ENG-SP20008-R4-PrelimPlan-redlines.pdf Markup Summary

HOMESTEAD NORTH PHASE 1

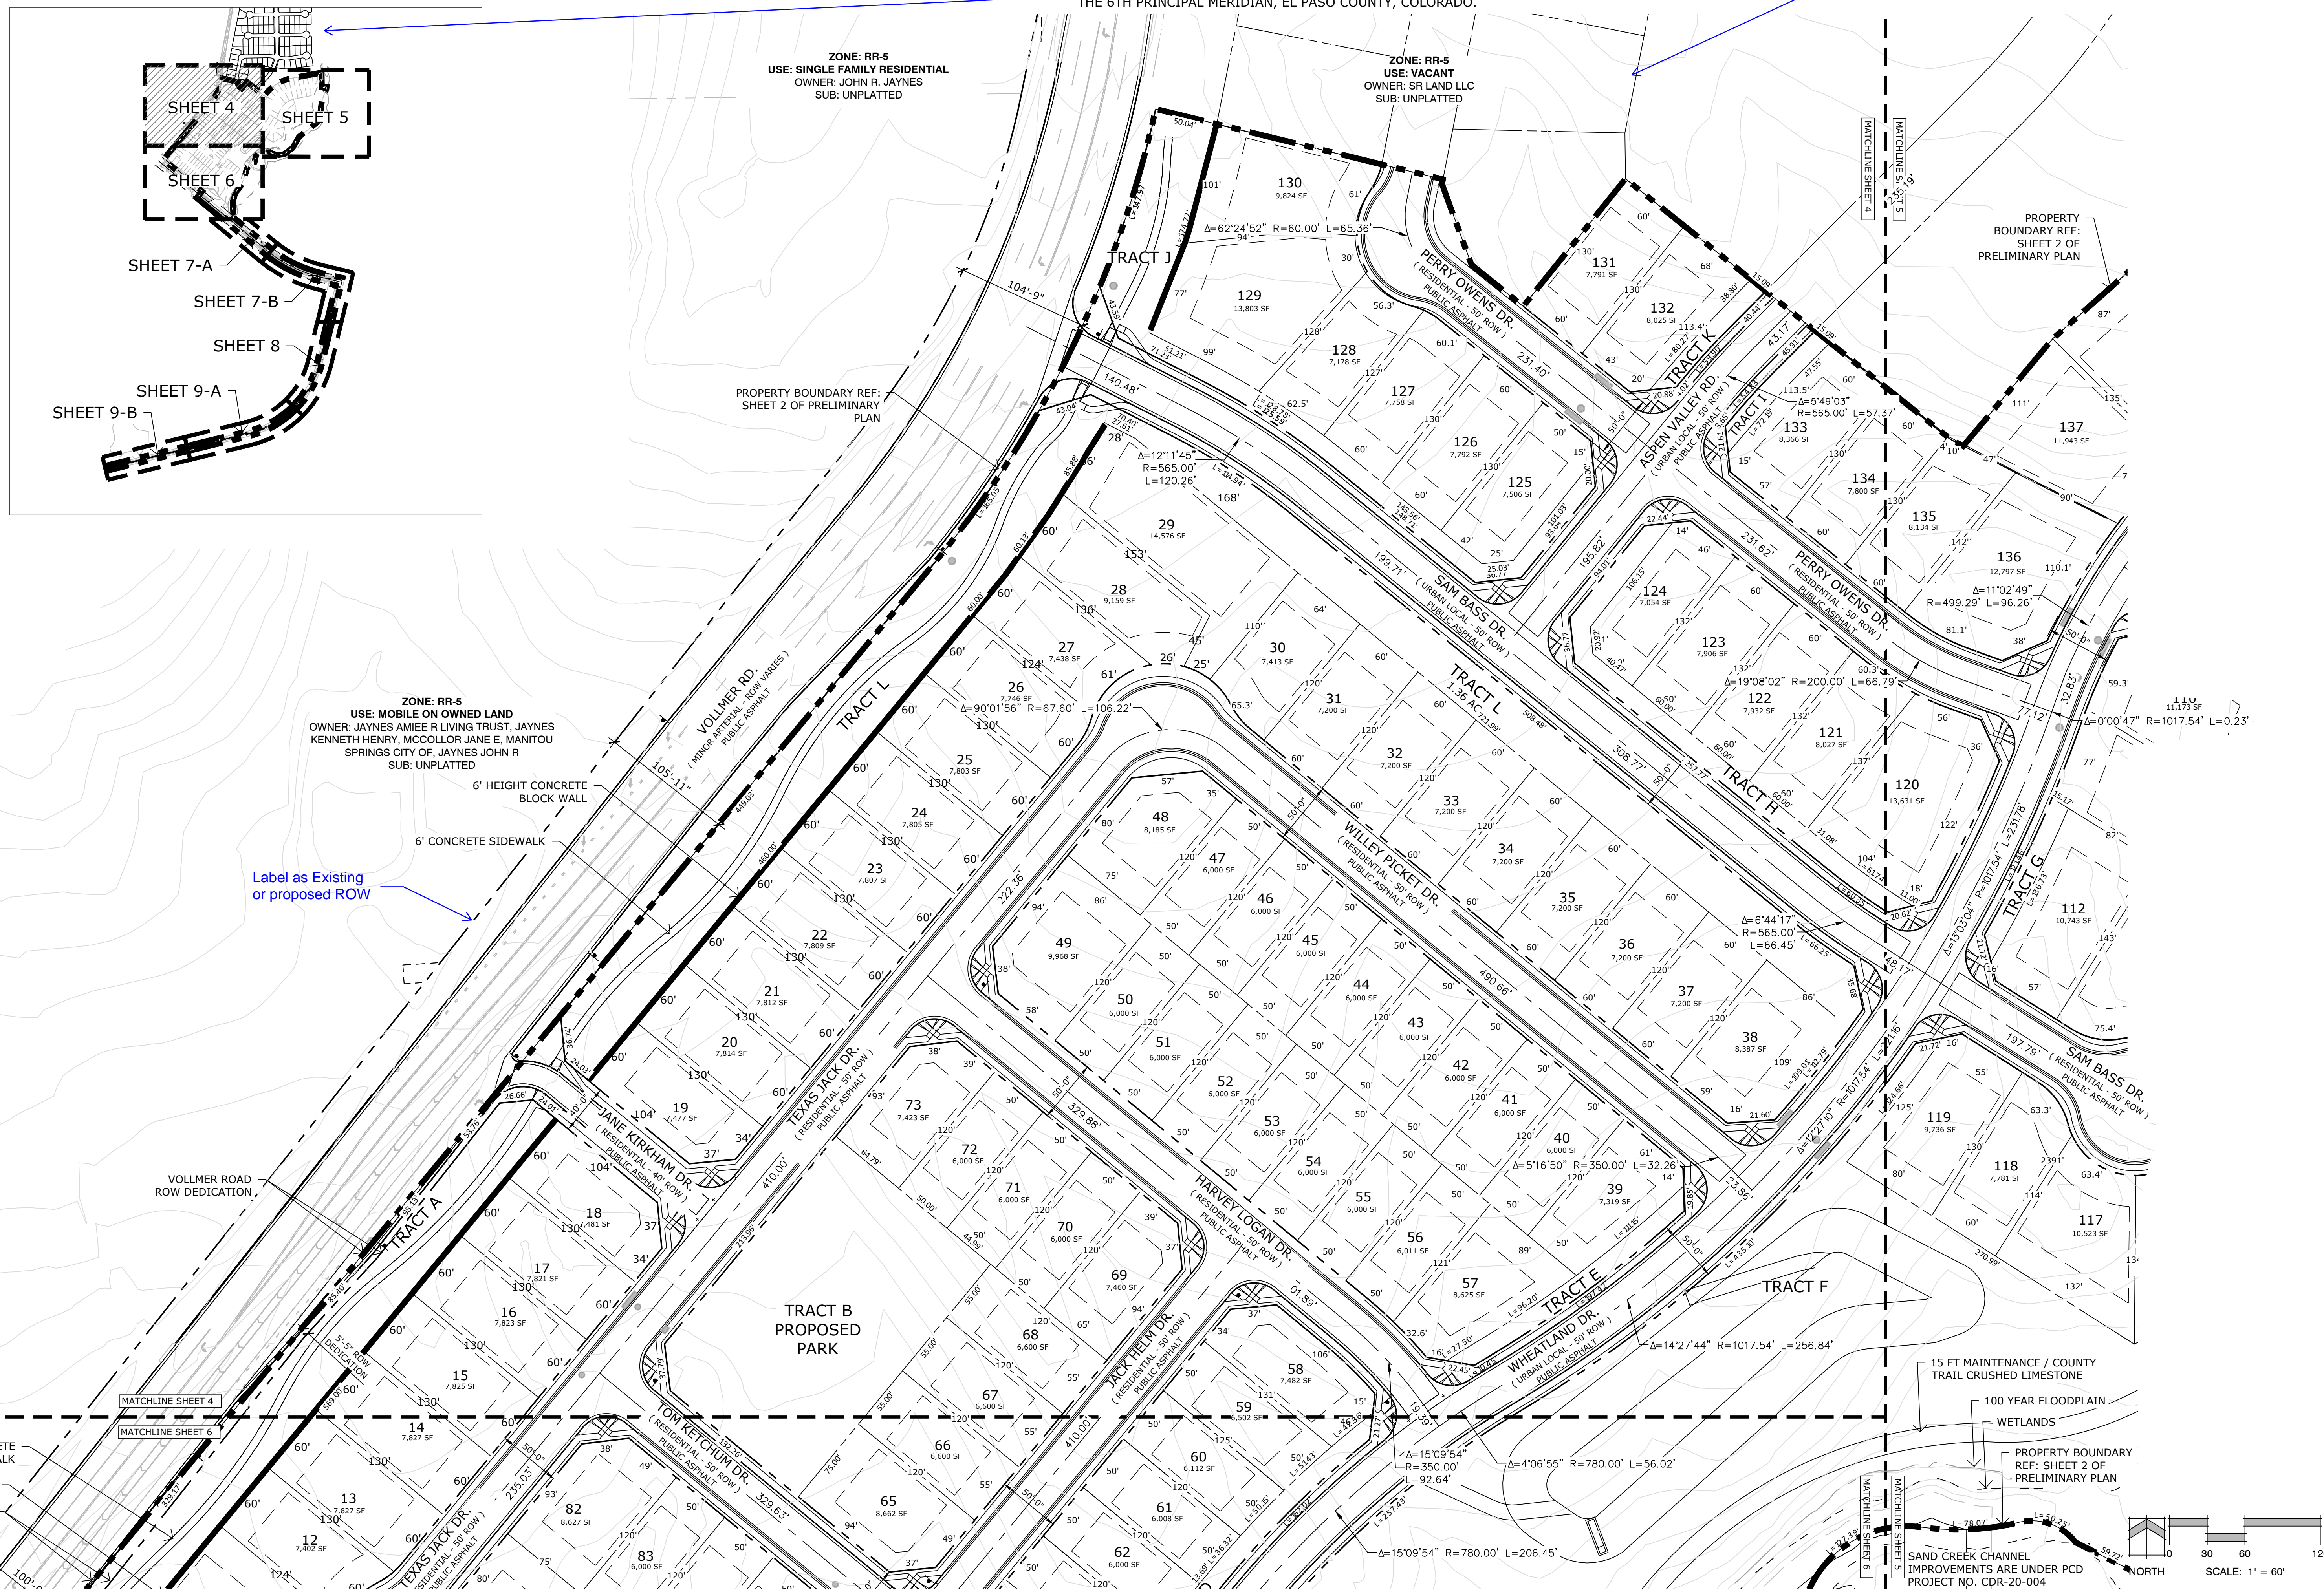
Is a continuous accel-decel lane being provided?

Show and label ROW dedication.

These lanes/transitions don't make sense. Show the ultimate road.

PRELIMINARY SITE PLAN

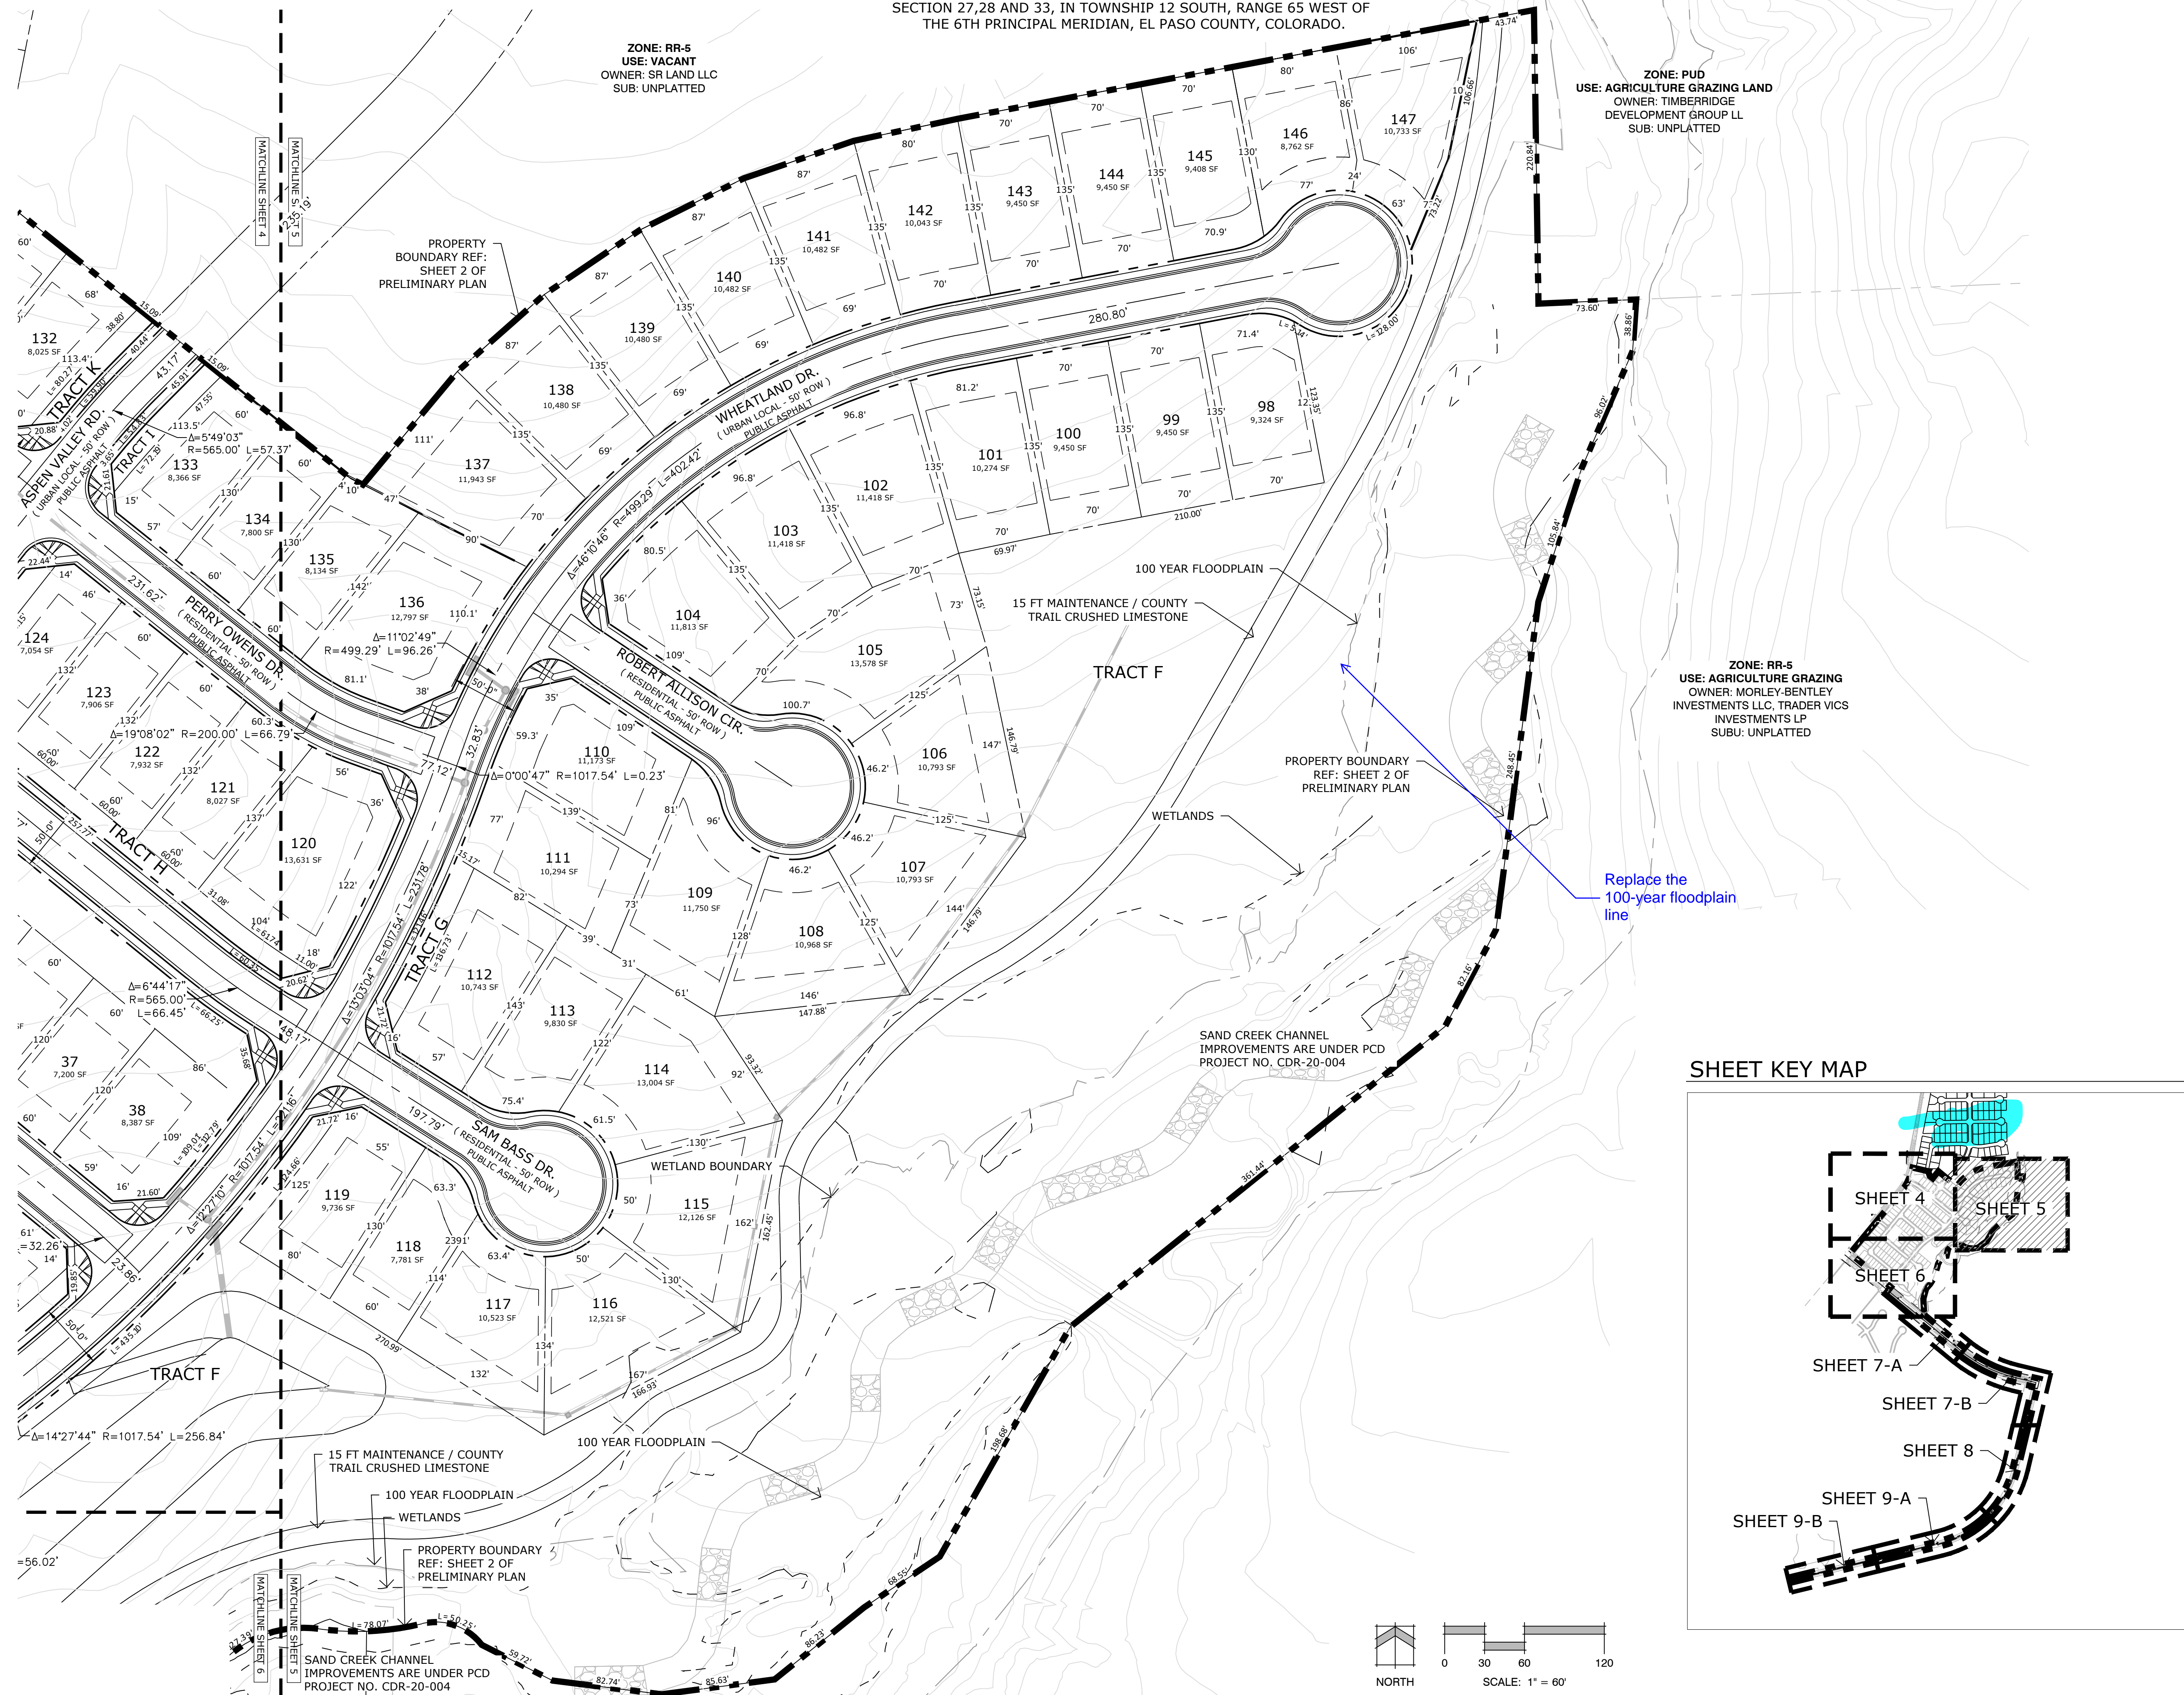
Label as Existing or proposed ROW

Label existing 60' and proposed ROW widths and lane widths

These lanes/transitions don't make sense. Show the ultimate road.

PRELIMINARY SITE PLAN

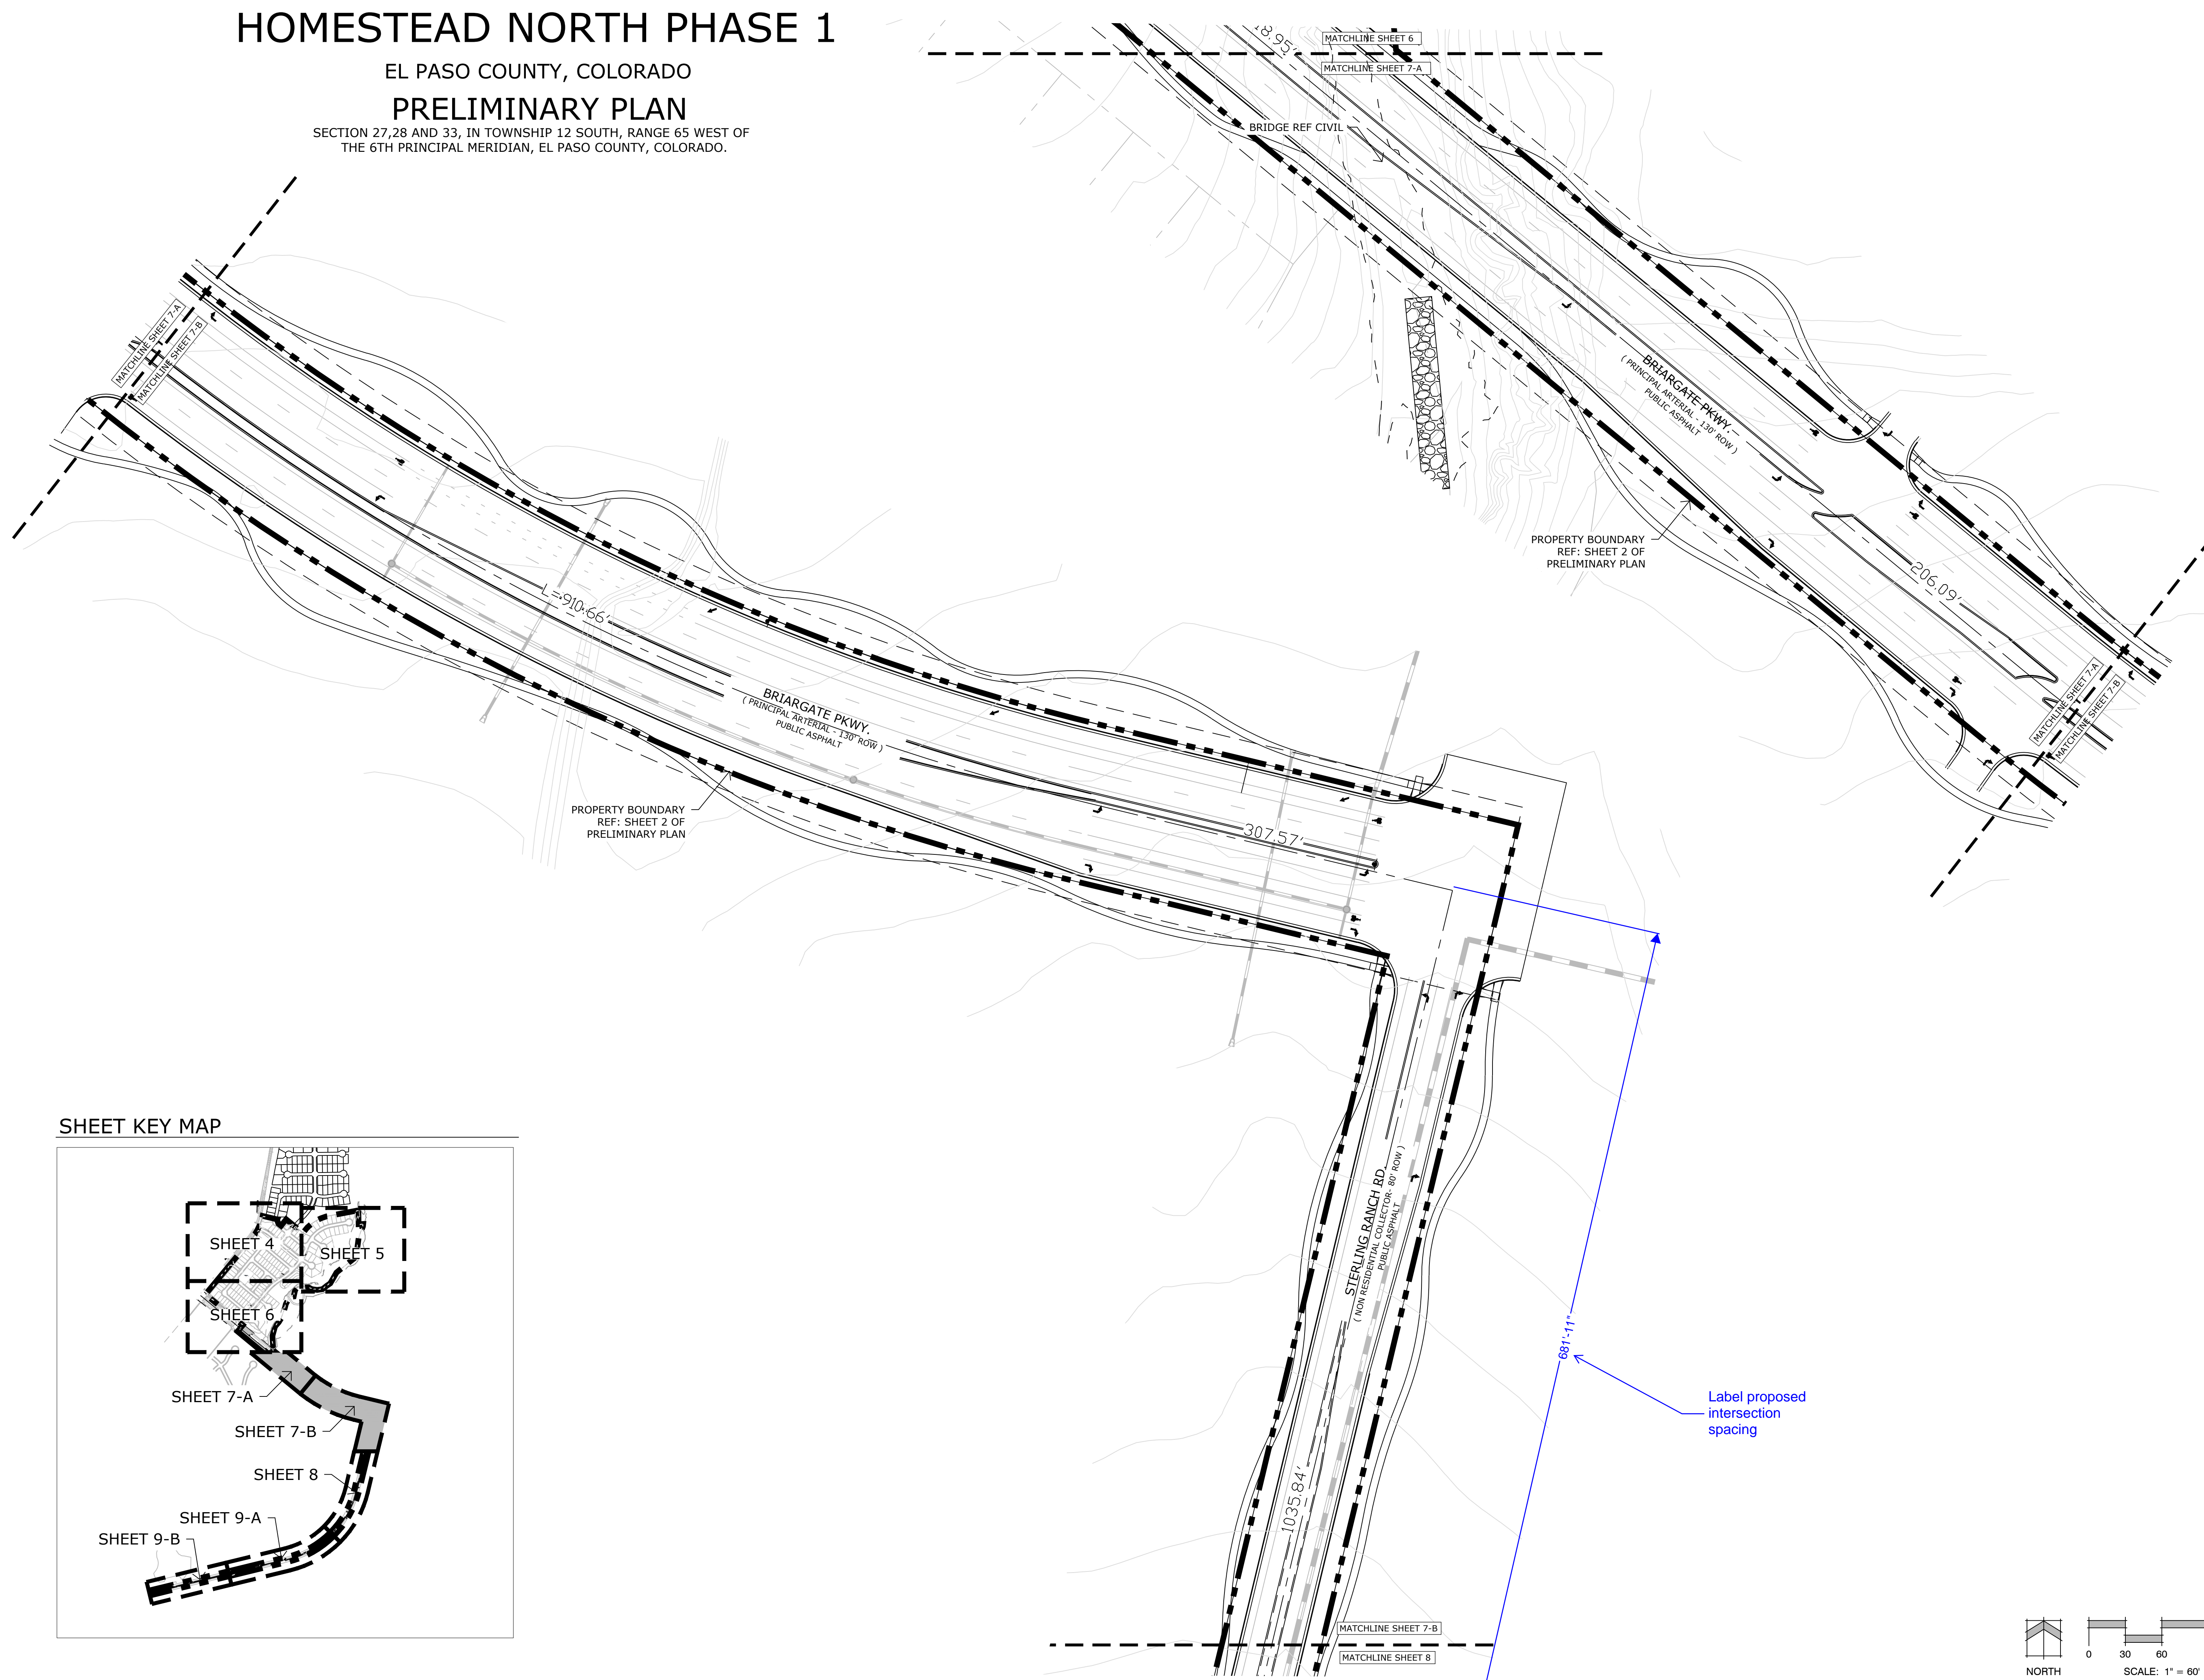
Subject: Callout
Page Index: 6 Show 15' maintenance access roads on each side of channel
Date: 12/1/2021 4:57:55 PM
Author: CDurham
Color: ■
Layer:
Space:
Page Label: [1] Sheet 6

Subject: Callout
Page Index: 6 Lanes don't make sense
Date: 12/12/2021 12:56:21 PM
Author: dsdrice
Color: ■
Layer:
Space:
Page Label: [1] Sheet 6
